**REVIEW OF RECOMMENDATIONS IN THE DG'S REPORT**  
**MIXED USE DEVELOPMENT CAMSPIE**  
**FORMER SUNBEAM FACTORY**

On 28 October 2009, the Minister for Planning requested the Planning Assessment Commission to undertake a review of the reasonableness of the Department's recommendation for a Concept Plan and Project Application for the redevelopment of the former Sunbeam factory at 60 Charlotte St, Campsie (see aerial photo attached).

Figure 10. Open Space – Levels

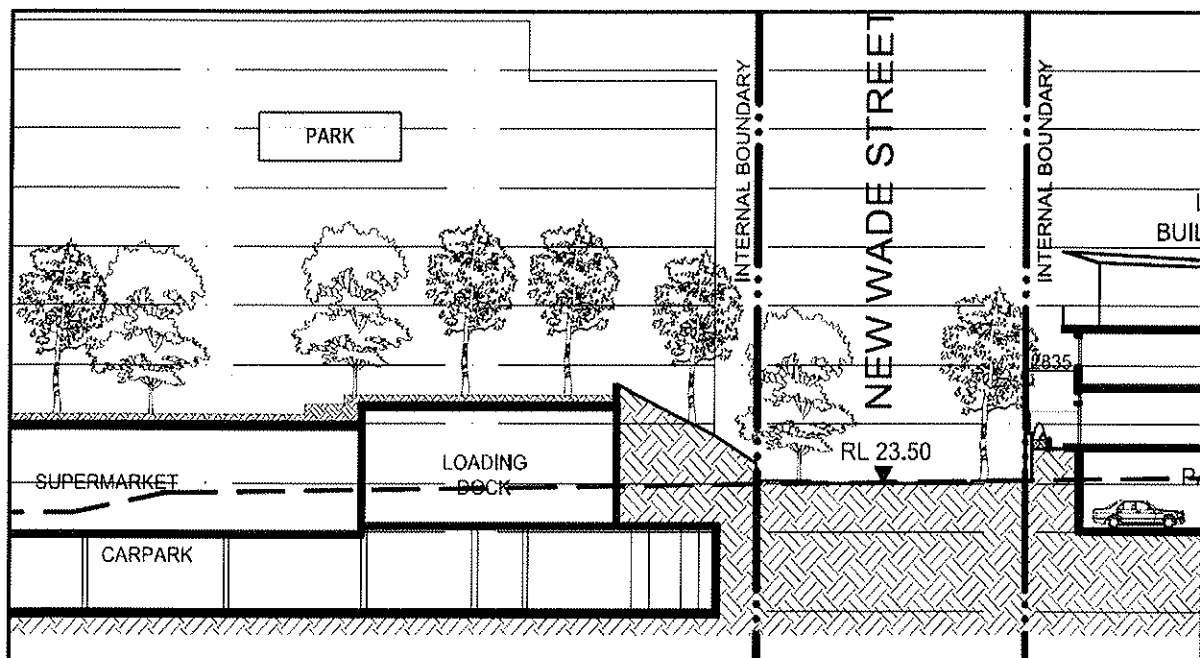
The proposed open space is located on a podium above a proposed supermarket carpark and loading dock. The main access to the park is from New Wade St, however as identified by the Department, the difference in levels between the street and the open space remains unresolved.

successful rooftop open space. The Commission considers the Department's recommendations requiring the Proponent to provide further design details to ensure that the proposed public open space corresponds to the public domain and is easily accessible to be reasonable for the park as proposed.
